The Coal  
Authority

**Re: Planning Application 2025/1067**

**Erection of sub-station; Land Off Dearne Valley Parkway, Rockingham Business Park, Hoyland, Barnsley**

Drawing Title
 GEOTECHNICAL CONSTRAINTS PLAN

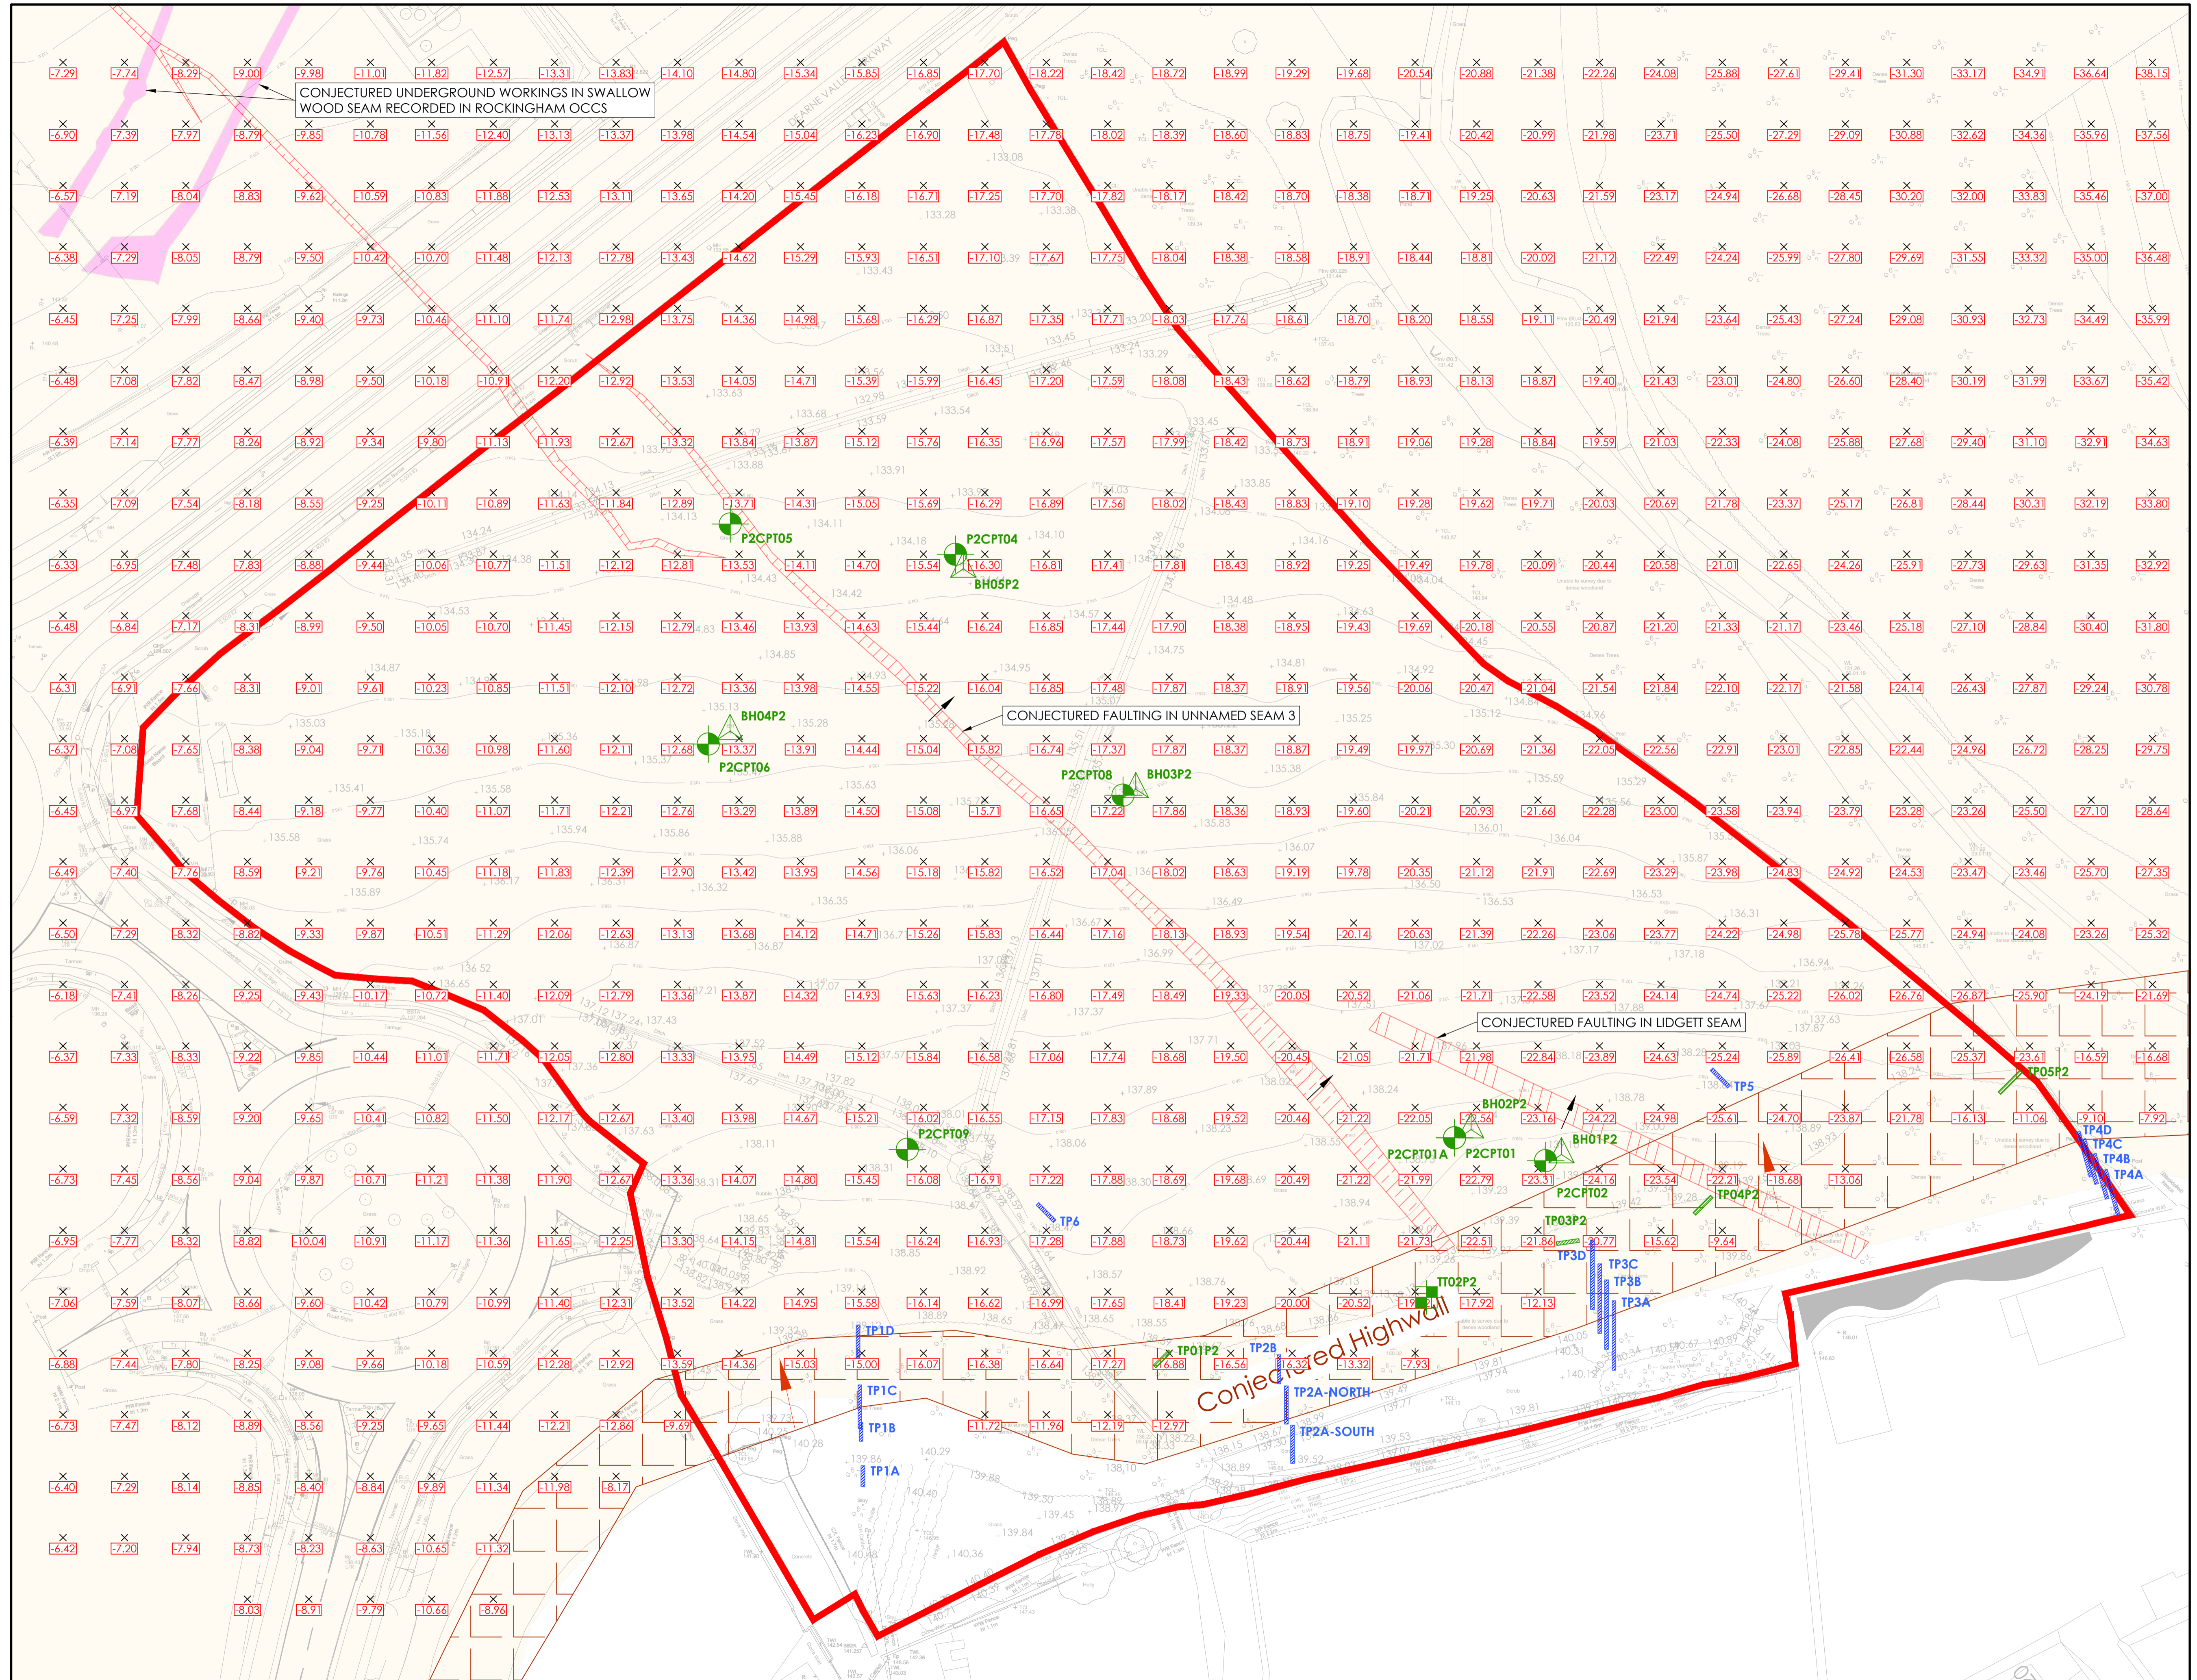
The report states that review of the abandonment plans has confirmed that surface mining has taken place on the site. The extent of the former surface mining and its associated highwall have been identified on the geotechnical constraints plan included in the report. The report authors comment that where the highwall is present there is a risk of differential settlement.

We note that the substation is positioned to the north of the surface mining highwall, as identified on the Geotechnical Constraints Plan, Dwg No 5419-JPG-SW-00-DR-G-0007. On the basis of the information submitted, and the professional opinions of the report authors set out therein, the Planning team have **no objection** to this planning application.
